Thank you for your email forwarding Council's final comments regarding the Nadine Street S75W, dated 14 March 2017.

Road Reserve Width

PROPOSED RESIDENTIAL SUBDIVISION

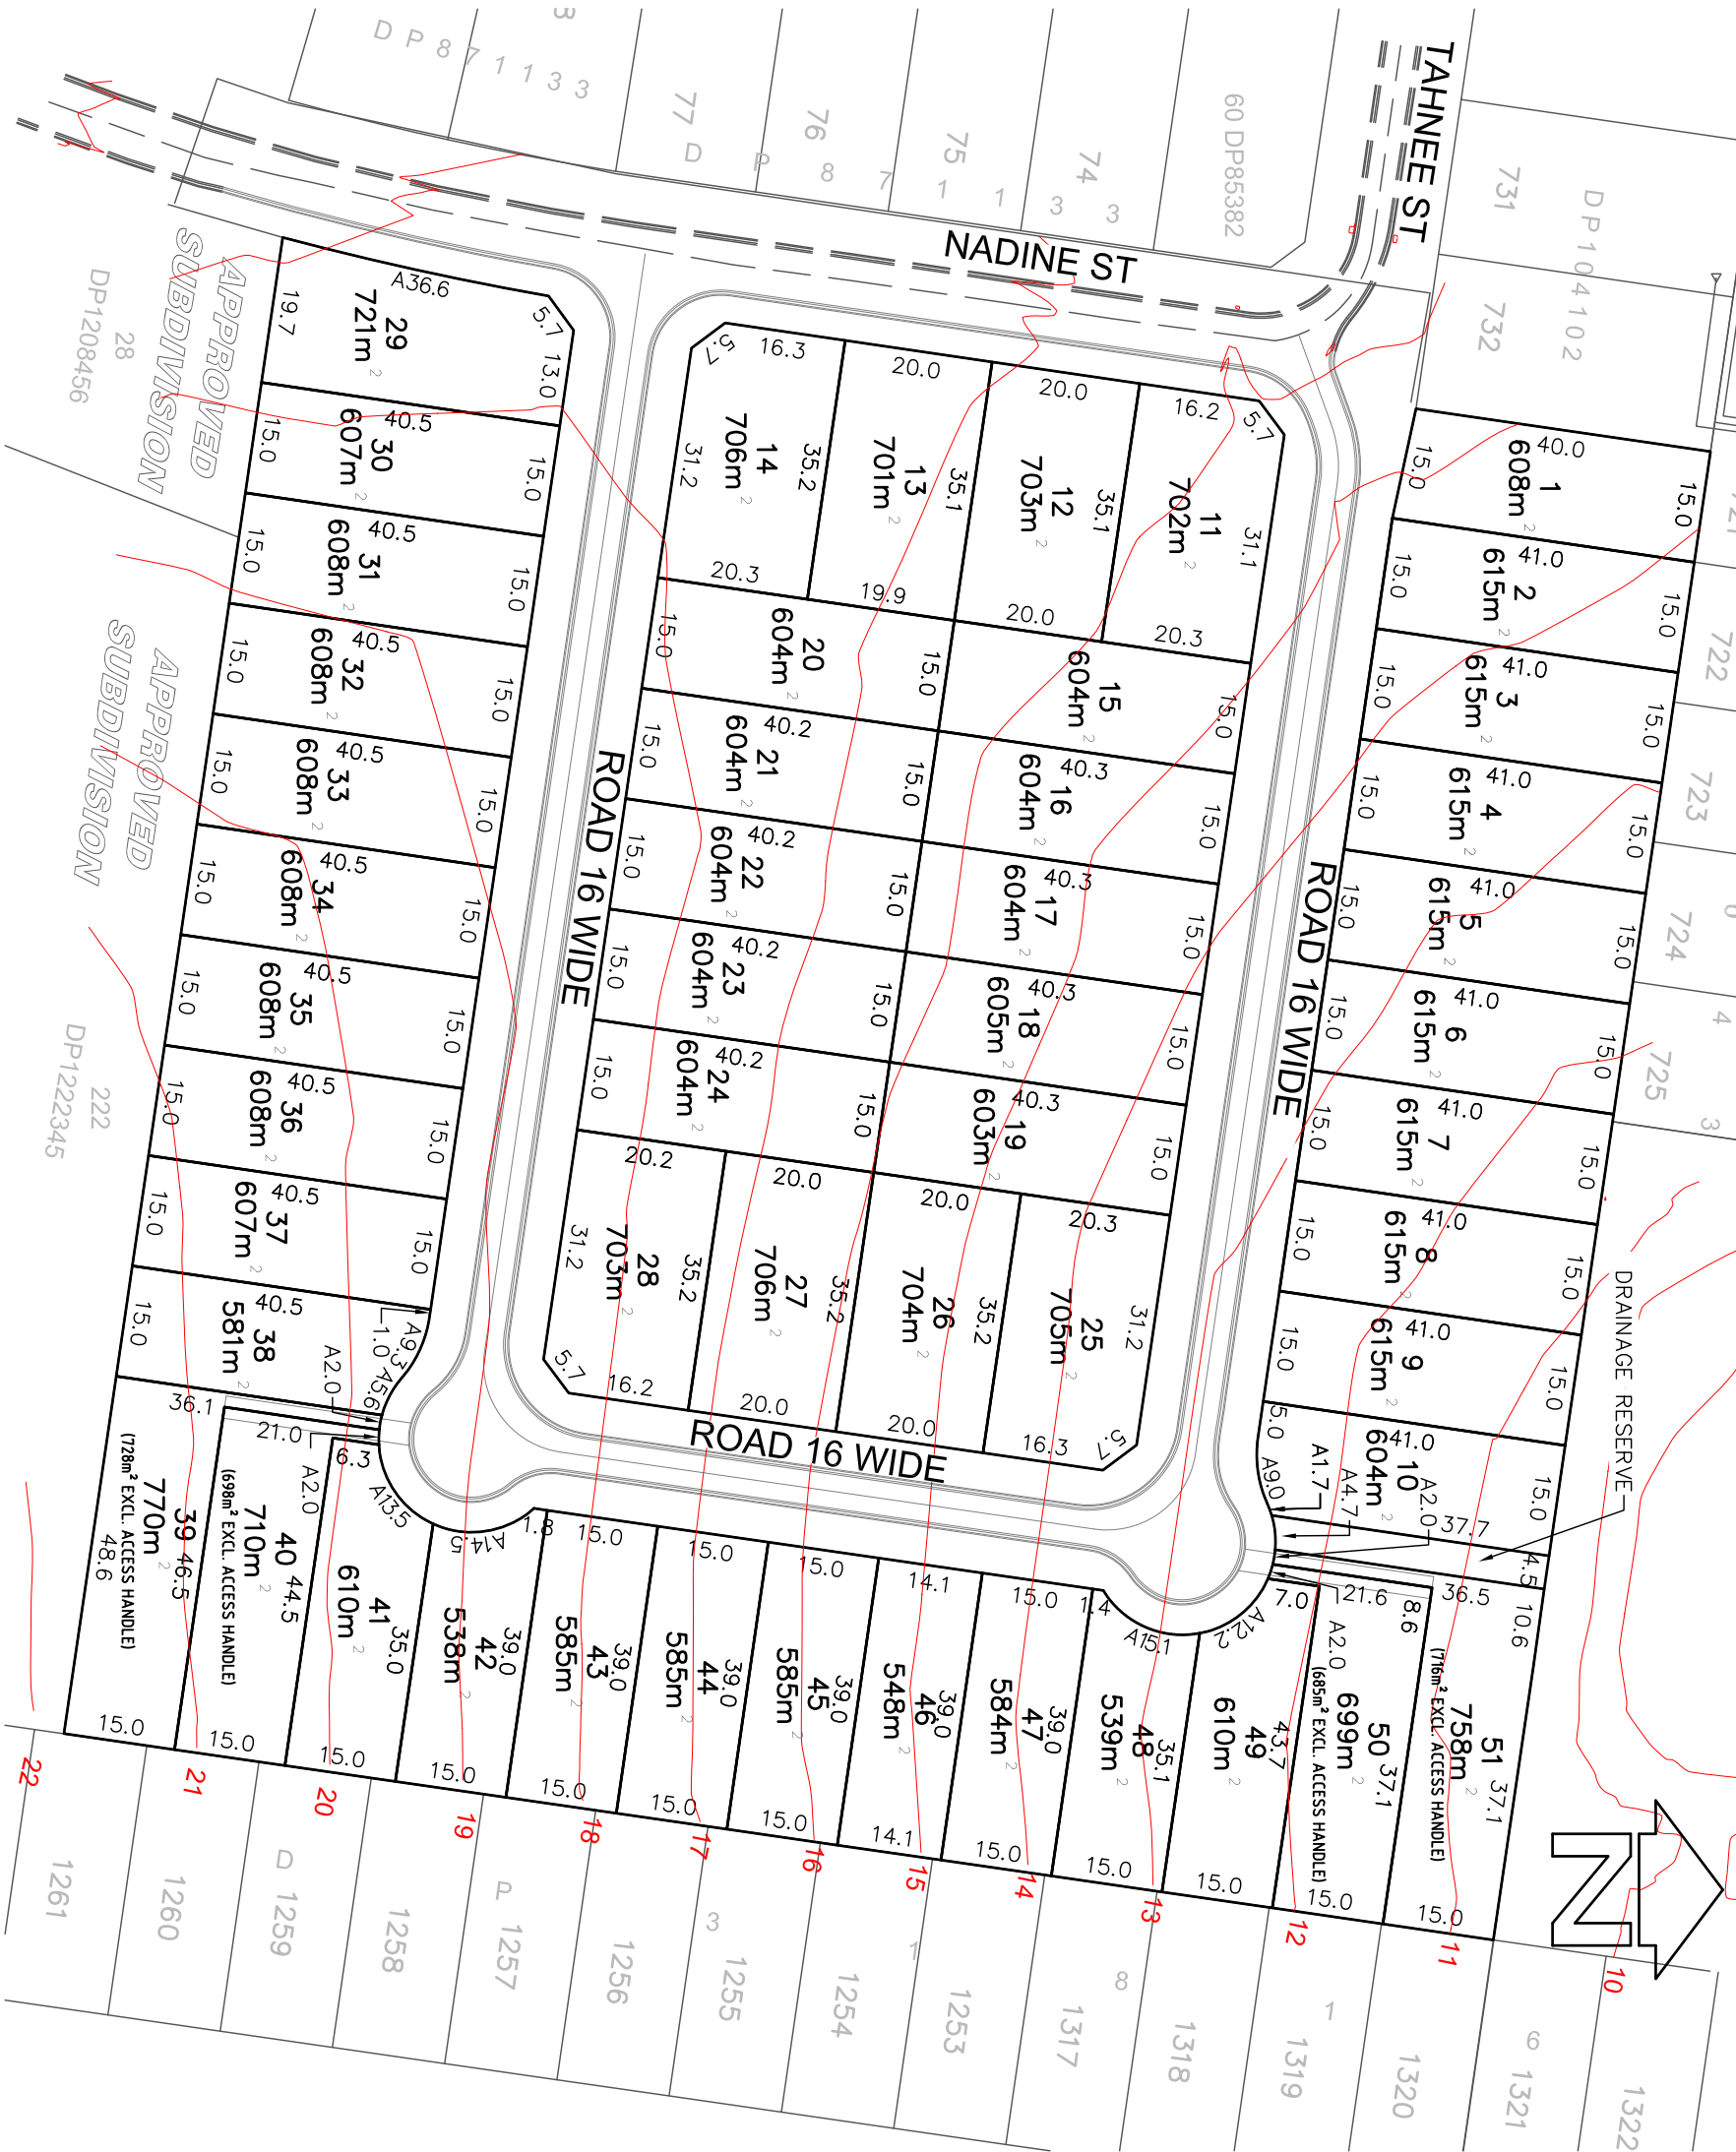
Lot Layout

Details of the further subdivision of corner allotments 39 and 41 respectfully are not required as our clients have no plans for development of the respective sites at this time. Further development of the subject allotments can be assessed on merit, if a future Development Application is lodged for any intensification of development on the corner sites.
